REQUEST

Current Zoning: R-3 (single family residential)
Proposed Zoning: UR-2(CD) (urban residential, conditional)

Approximately 11.65 acres located on the east side of Mallard Creek Road, north of Governor Hunt Road, and west of David Taylor Drive.

The petition proposes a residential for sale community of up to 132 townhome style multi-family dwelling units together with accessory uses permitted in the UR-2 zoning district.

RZ1.00

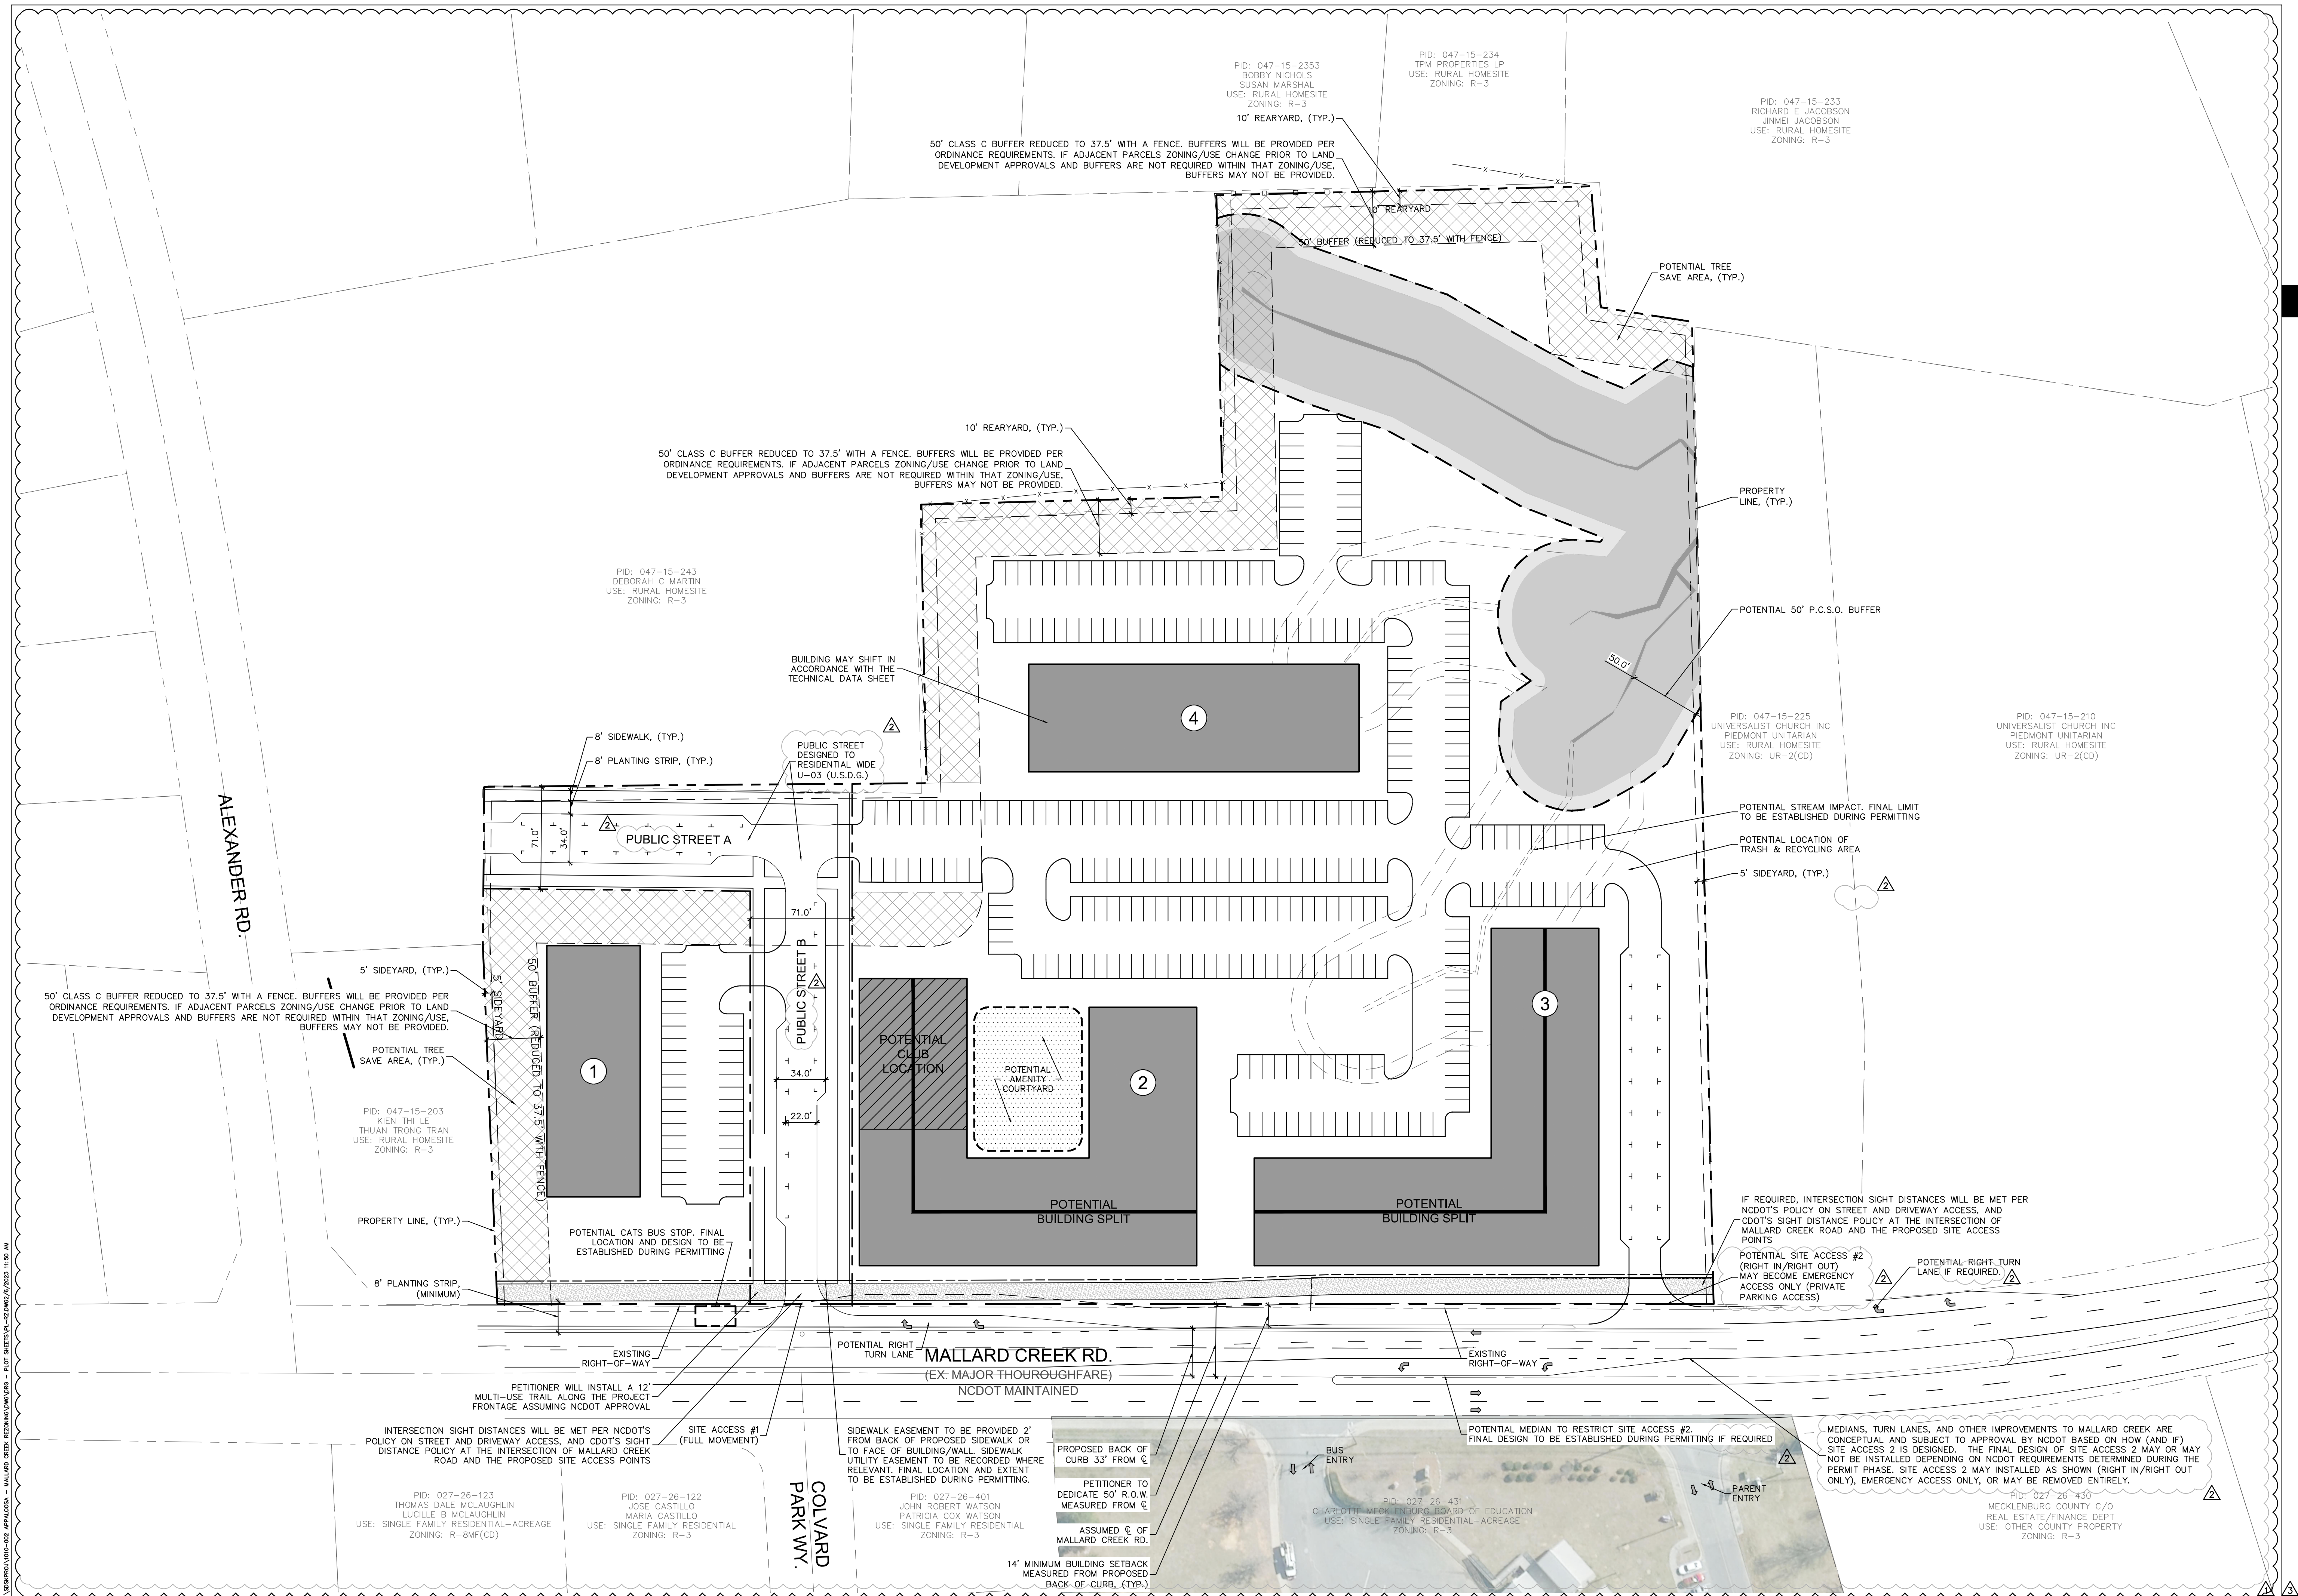
1. ~~Private Street A and Private Street B will both need to be public streets per coordination with subdivision. Remove all references to private access easements for Private Streets A and B.~~ Addressed
2. ~~Modify median to ensure full movement for development adjacent can be retained from parcels 04715225 and 04715210. What is being proposed will create a change of access for the development adjacent to property.~~ Addressed
3. ~~Either remove conditional note L or add as approved by NCDOT/CDOT at the end.~~ Addressed
4. ~~Remove word "potential" on callout for right turn lanes at site accesses. This is an NCDOT requirement. Add conditional note regarding right turn lanes at each site access. Label and dimension right turn lanes.~~ Addressed
5. ~~Remove "assuming NCDOT approval" on callout for 12-foot multi-use trail.~~ Addressed
